DRB Application No.: 06DRB-00645 (P&F)  
Project Name: FITZGERALD ADDITION  
Agent: Surveys Southwest Ltd

SURVEYS SOUTHWEST agent(s) for DUNCAN MILLOY request(s) the above action(s) for all or a portion of Lot(s) 5, Block(s) 1, **FITZGERALD ADDITION**, zoned R-1, located on FITZGERALD RD NW, between CANDELARIA RD NW and 4<sup>TH</sup> ST NW containing approximately 1 acre(s). [REF: 06DRB-00414] (G-14) **THE PRELIMINARY AND FINAL PLAT WAS APPROVED AND SIGNED OFF BY THE BOARD.**

**RE: Lot 5, Fitzgerald Addition/sketch**

SKETCH PLAT OF
 LOTS 5-A & 5-B, BLOCK 1
 FITZGERALD ADDITION
 WITHIN PROJECTED SECTION 5, T. 10 N., R. 3 E., N.M.P.M.
 TOWN OF ALBUQUERQUE GRANT
 CITY OF ALBUQUERQUE
 BERNALILLO COUNTY, NEW MEXICO
 MARCH 2006

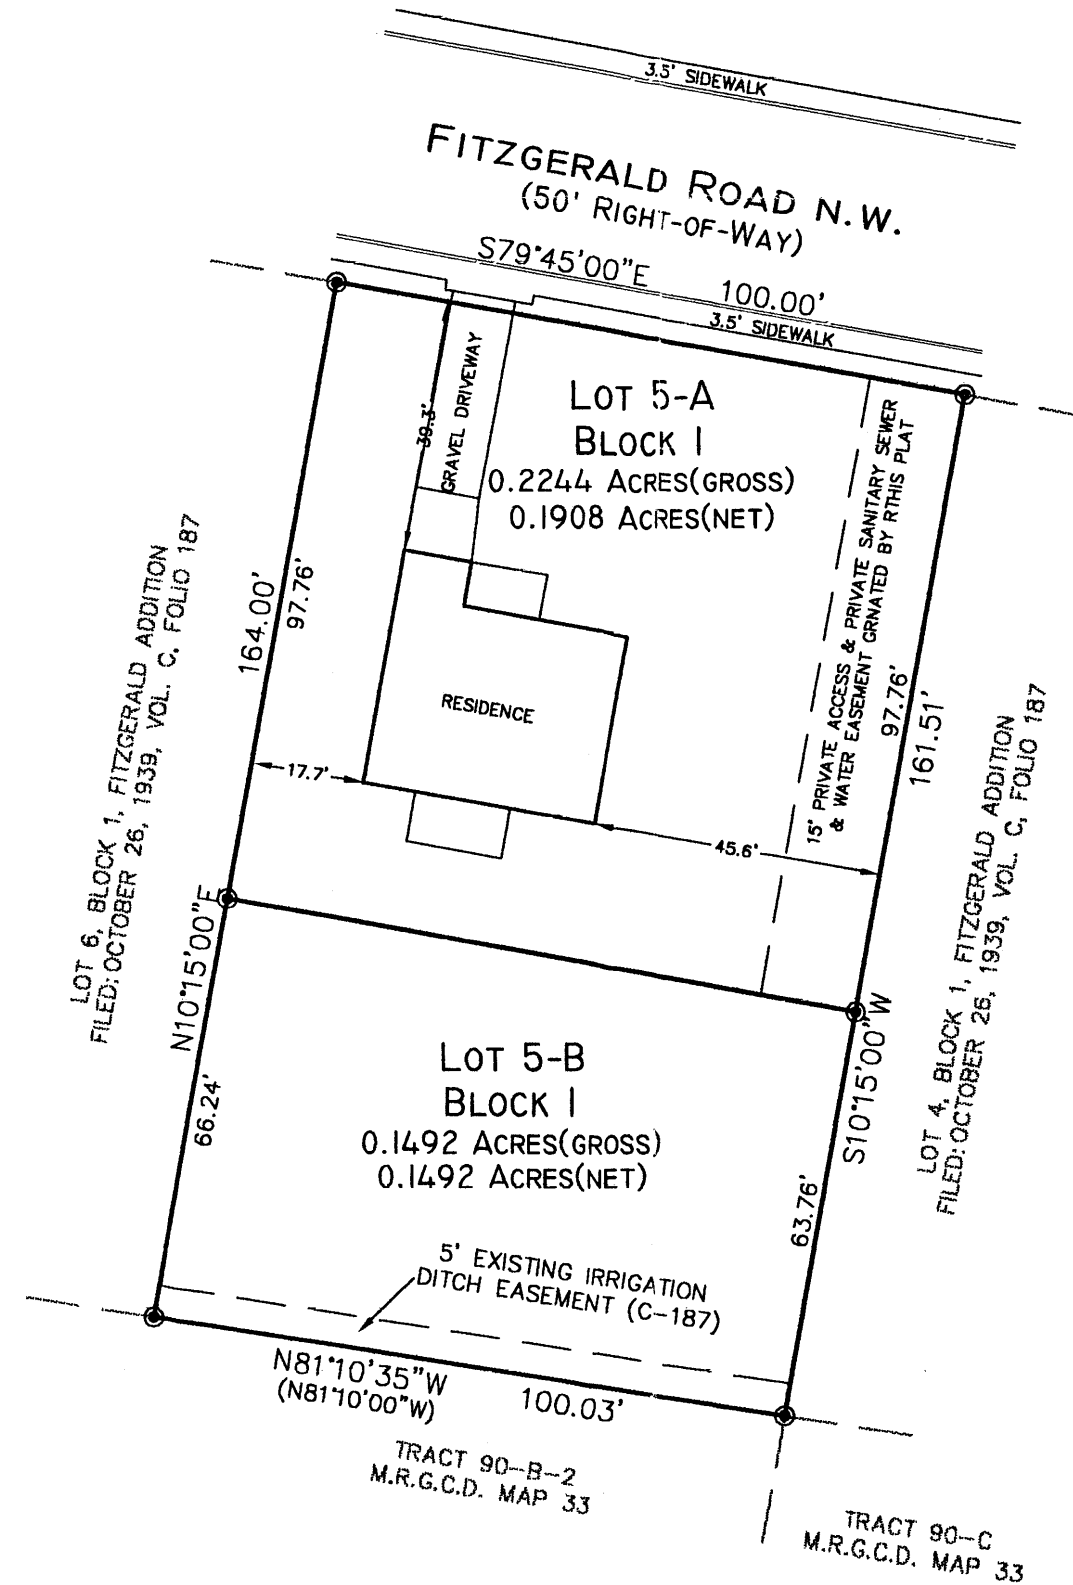
According to AGIS, the zoning on this property is R-1. The application has R-2.

The sketch plat shows 2 lots, both of which meet the minimum lot width of 60 feet and lot size of 6,000 square feet. The letter says both lots are over 8,000 square feet. One is just over 6,000 square feet.

Where is the rear of the present home? The front appears to face northeast. If this is the case, R1 zoning has a 15 foot rear yard setback. Is there 15 feet from the rear of the house to the new proposed lot line?
